About the application

Application number: 2023/92127	
What is the application for?:	Alterations to convert church to 2 dwellings, formation of residents car park, e
Address of the site or building:	Church of the Holy Innocents, Vicarage Road, Dewsbury, WF12 9PD
Postcode:	BD19 5LX

PROPOSED SITE PLAN SCALE 1:100

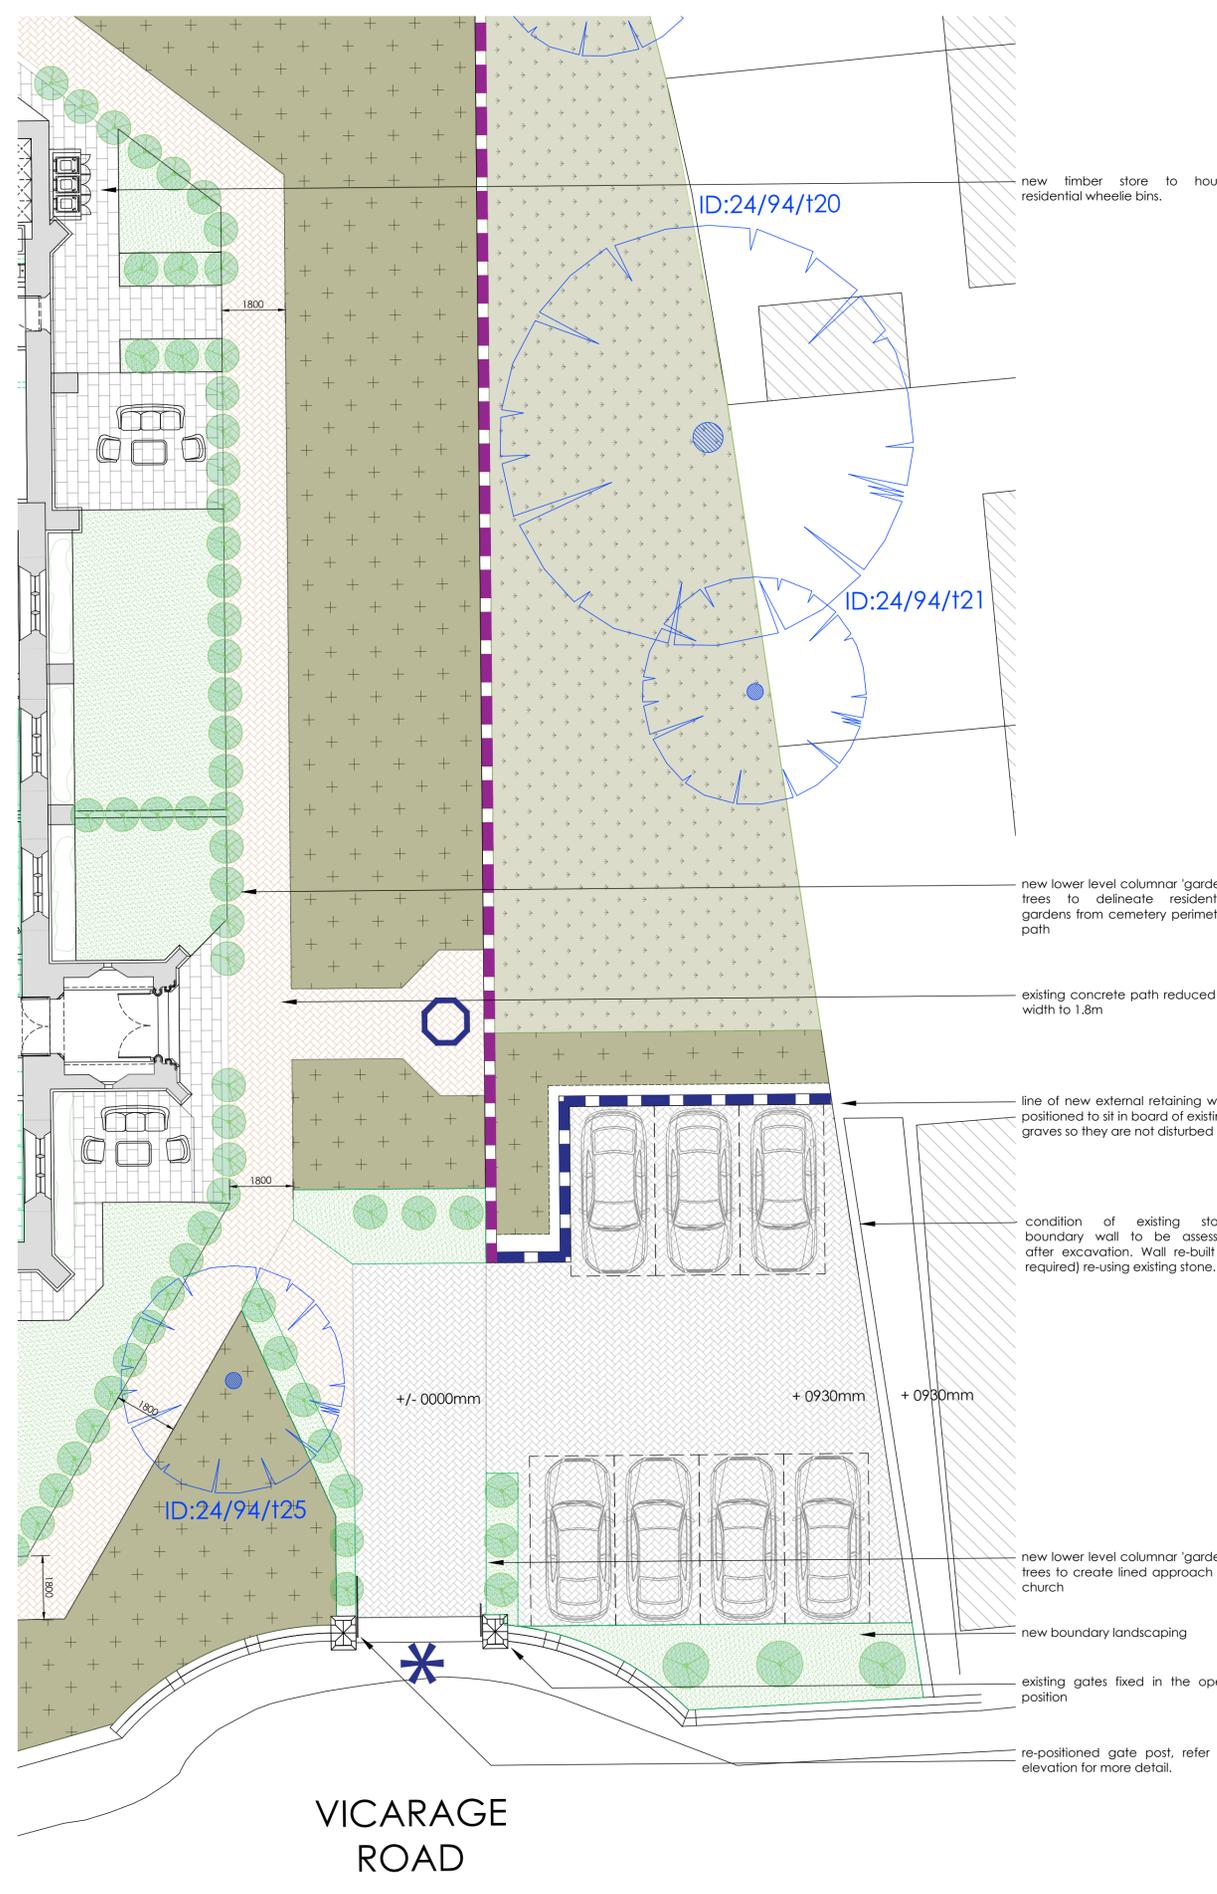
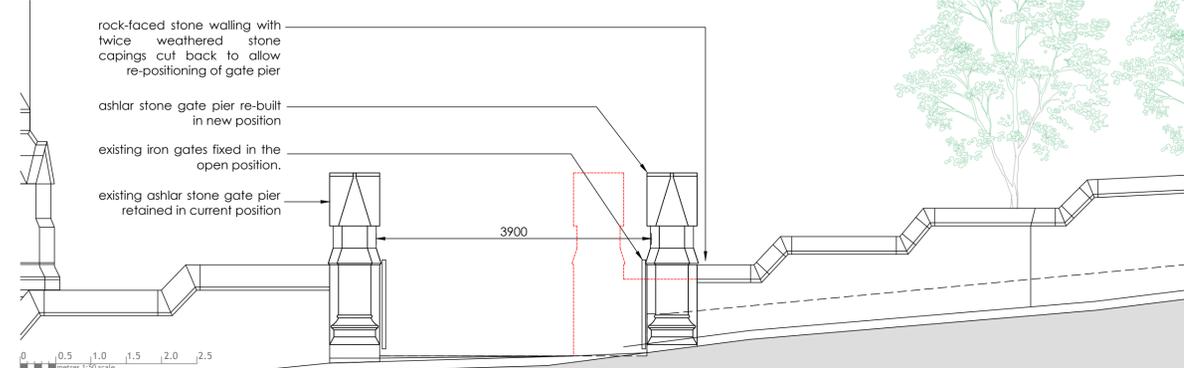
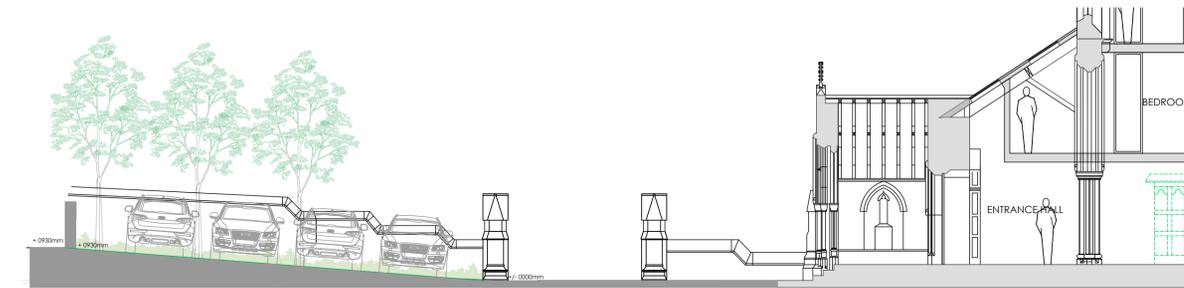
Type of comment: An objection	
Do you wish your comments to be published on the website anonymously?	Yes
Having looked through the planning application I would like to know how families will be able to enter the church grounds to maintain loved ones graves
